From: Tri Valley Crop Insurance <trivalleycropinsurance@gmail.com>
Sent: Wednesday, September 30, 2026 8:46 AM
To: Ellie Myers
Subject: Opposing SP-26-000010, Brown Road Estes II

e: Written Comments Opposing SP-26-00010, Brown Road Estates II

Parcels 953834 & 428333 • 100 & 300 Anderville Lane, Ellensburg, WA

Applicant: Brown Road Estates, LLC

BROWN ROAD SHORT PLAT NO. 3  
PART OF SECTION 4, T. 17 N., R. 18 E., W.M.  
KITTITAS COUNTY, WASHINGTON

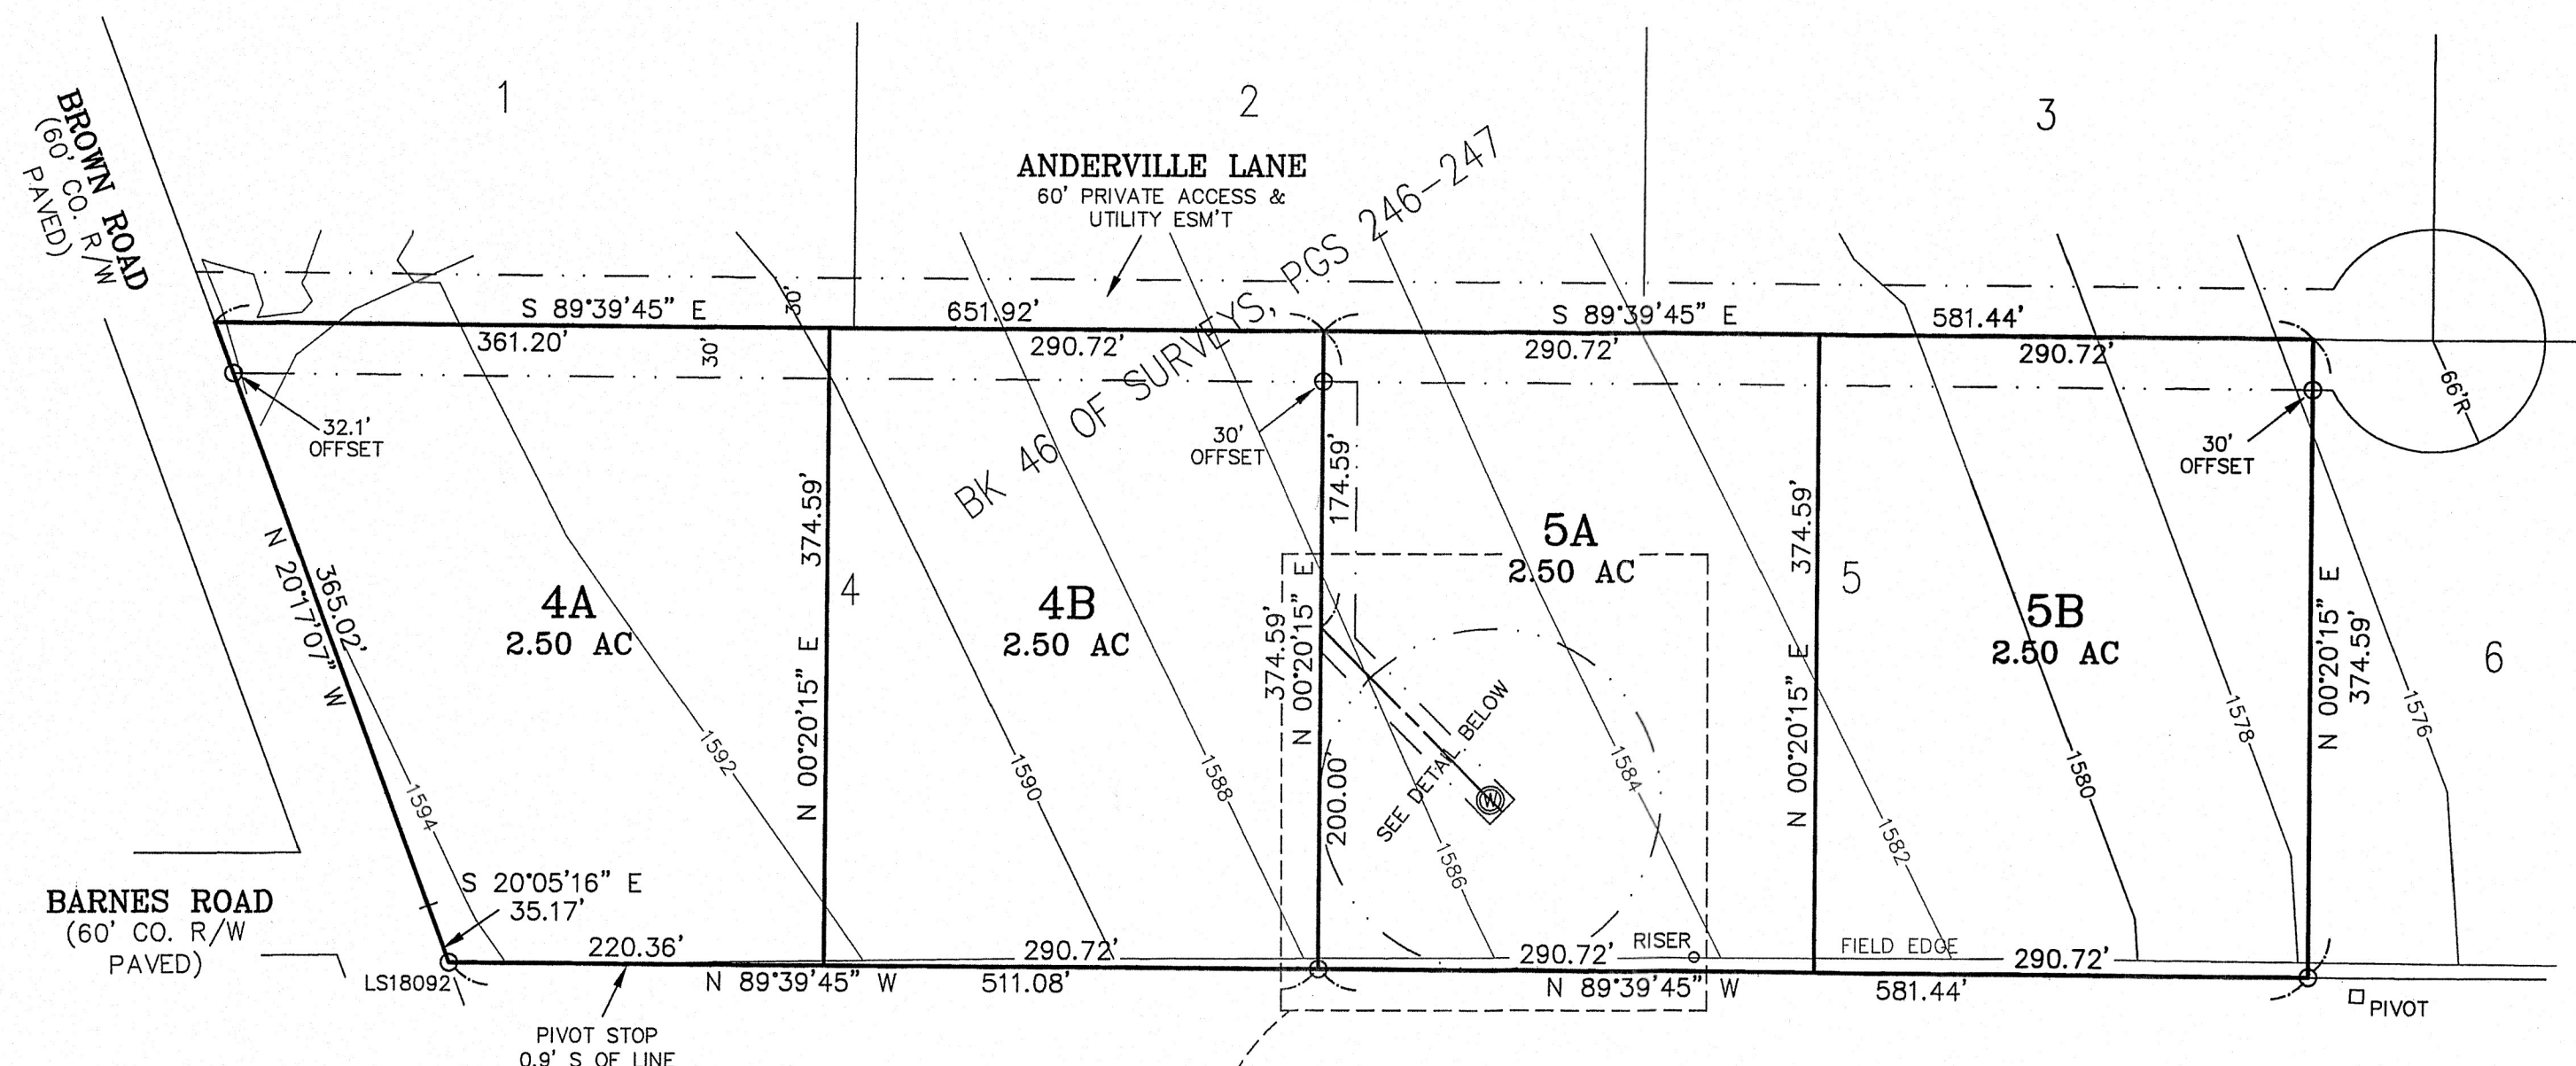
The applicant proposes four 2.5-acre lots on land zoned Agriculture-5 and states that TDR Density Credits in the form of TDR Certificates will be used “to meet the requirements of the density being requested to comply with zoning regulations.” That use of TDR is inconsistent with Washington State TDR policy, the Growth Management Act, and Kittitas County Code.

1. Agriculture-5 does not permit 2.5-acre lots.

The Agriculture-5 zone requires a five-acre minimum lot size. A short plat outside an urban growth area may create no more than four lots under KCC 16.08.186 and Chapter 16.32, but each lot must still meet the underlying zone. TDR credits are not a variance from minimum lot size and are not a rezone.

The only small-lot exception in KCC 16.12.040 is a single one-to-three-acre lot around an existing residence, subject to a covenant precluding further division while the land remains designated for agricultural use. That exception does not authorize four 2.5-acre lots across two parcels.
